Application for a Non-Material Amendment Following a Grant of Planning Permission

Gatehill Road

Application Ref: 32267/APP/2019/1289

NON MATERIAL AMENDMENT APPLICATION

PROJECT NAME AND ADDRESS
20 Gatehill Road
Northwood
HA6 3QD
APPROVED AND PROPOSED
ELEVATION BB and DD

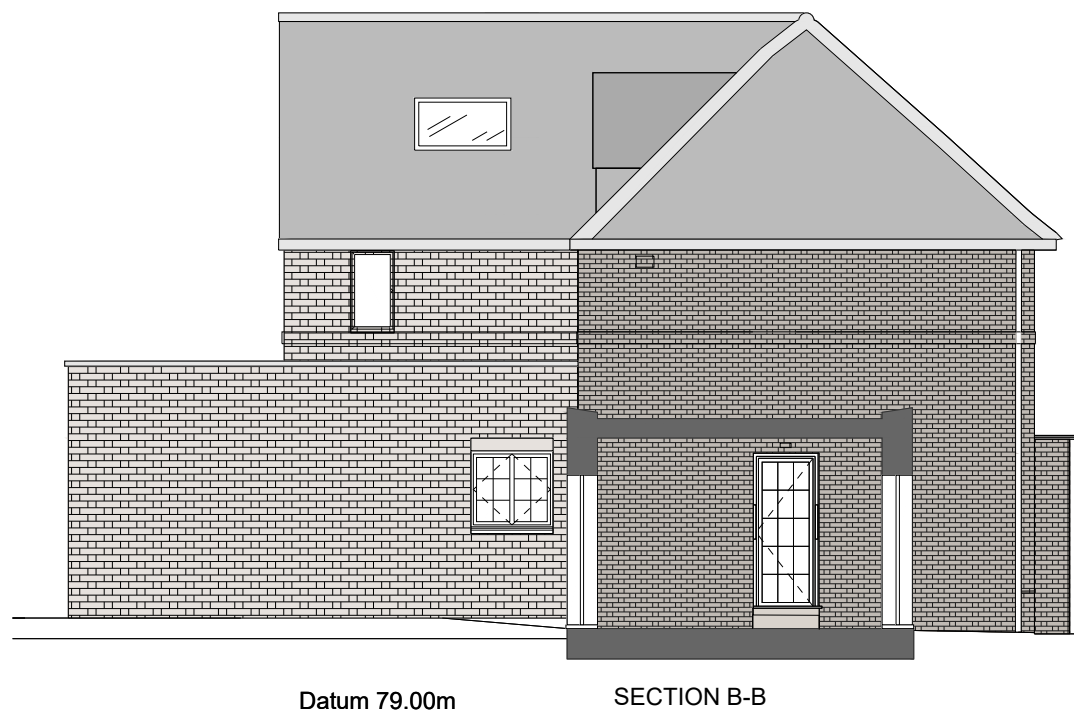
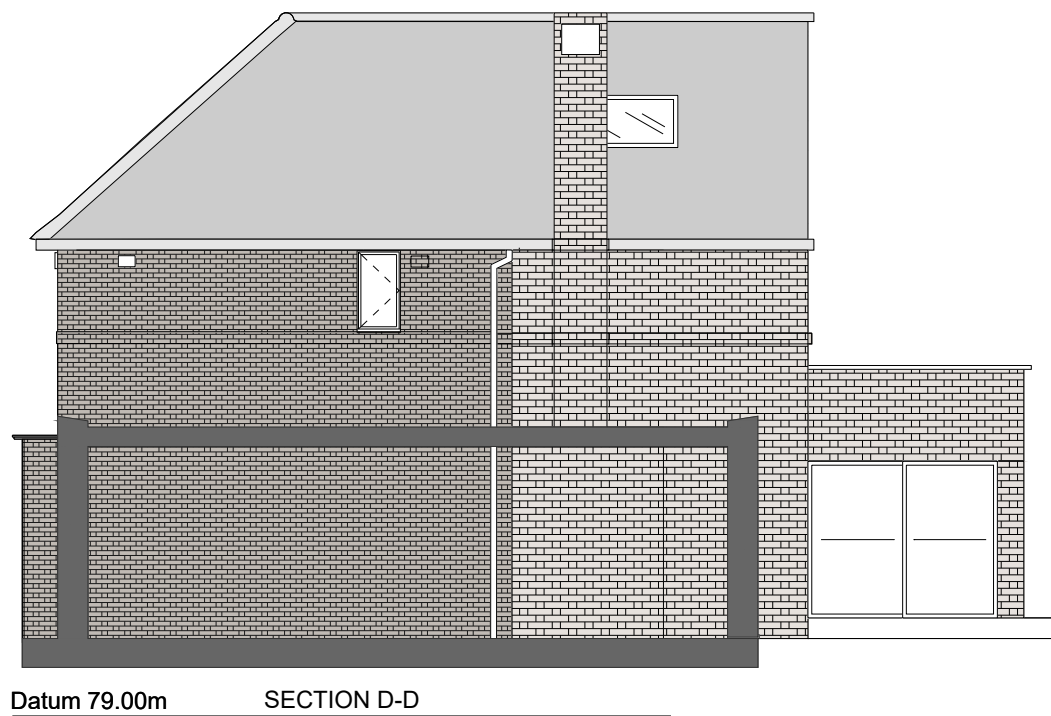
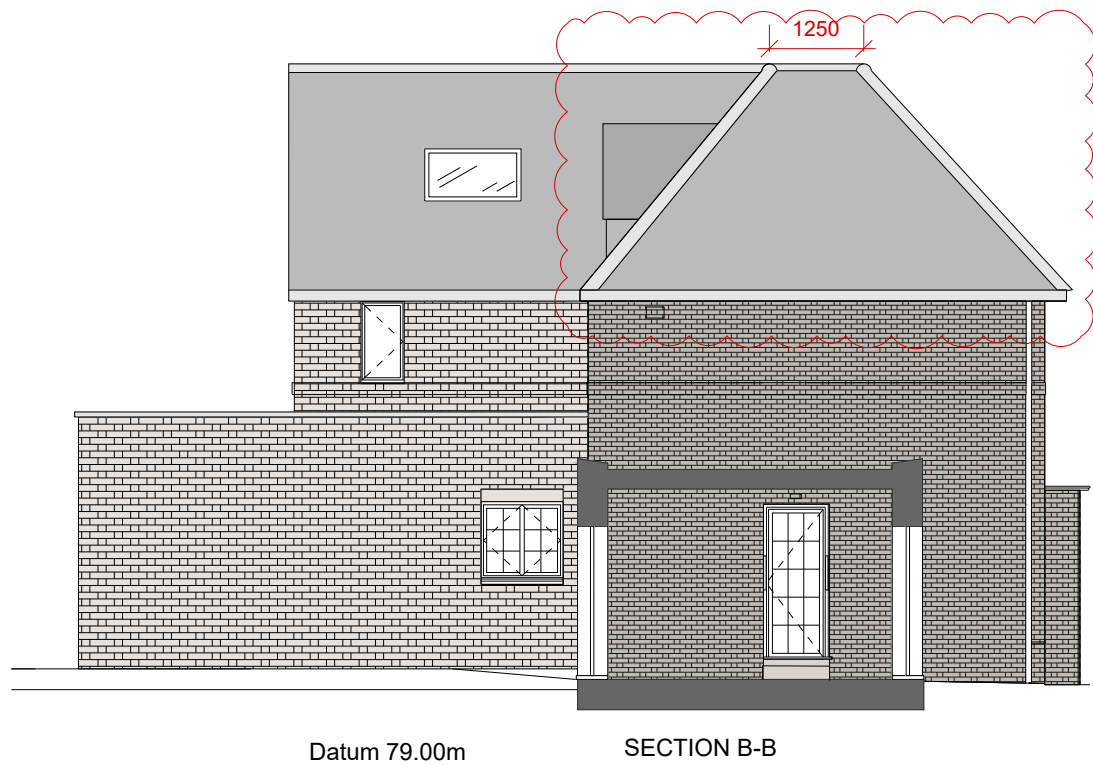
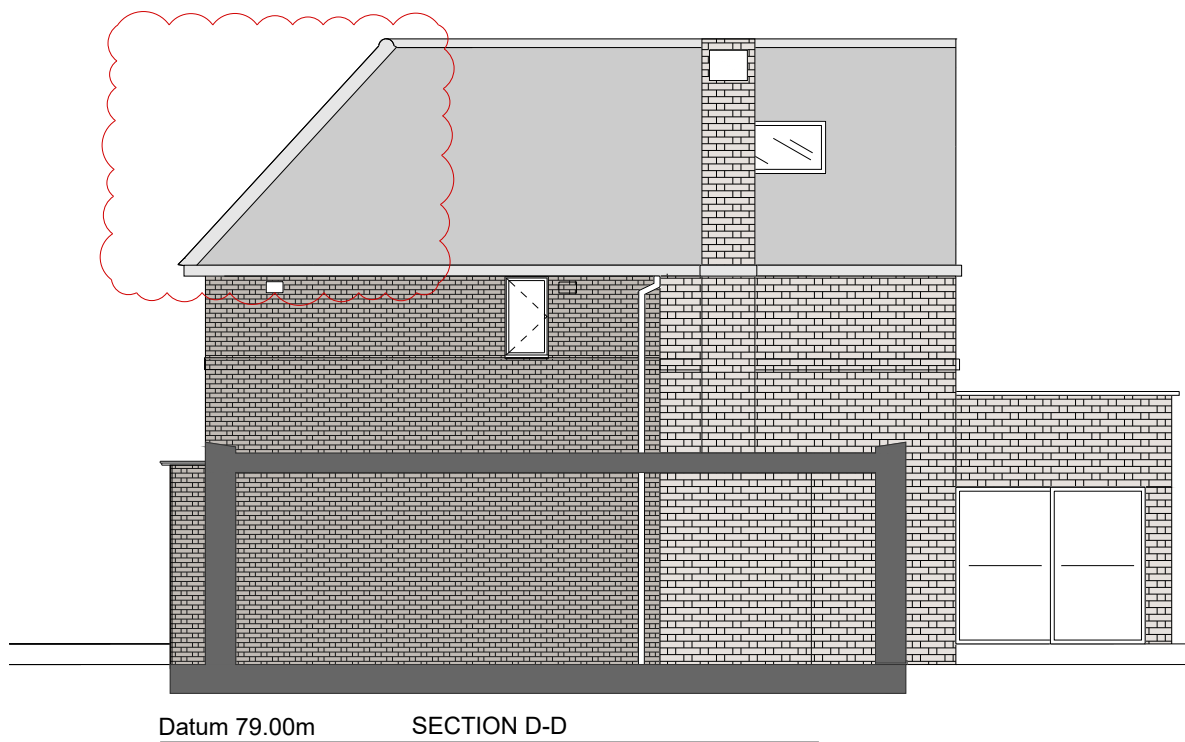
The proposed Minor Material Amendment introduces a small crown roof section; kept to the absolute minimum size depth 1250mm (in order to allow for the doors to be functional). The existing ridge height of the current roof is maintained.

Proposed Elevations BB and DD	TH16_GA_204 rev.F
Proposes Second Floor Plan	TH16_GA_202 rev. F
Proposed Section EE	TH16_GA_205 rev. E
Proposed Roof Plan	TH16_GA_203 rev. F

Proposed Elevations BB and DD	TH16_204_GA rev.G
Proposes Second Floor Plan	TH16_GA_202 rev. G
Proposed Section EE	TH16_GA_205 rev. F
Proposed Roof Plan	TH16_GA_203 rev. G
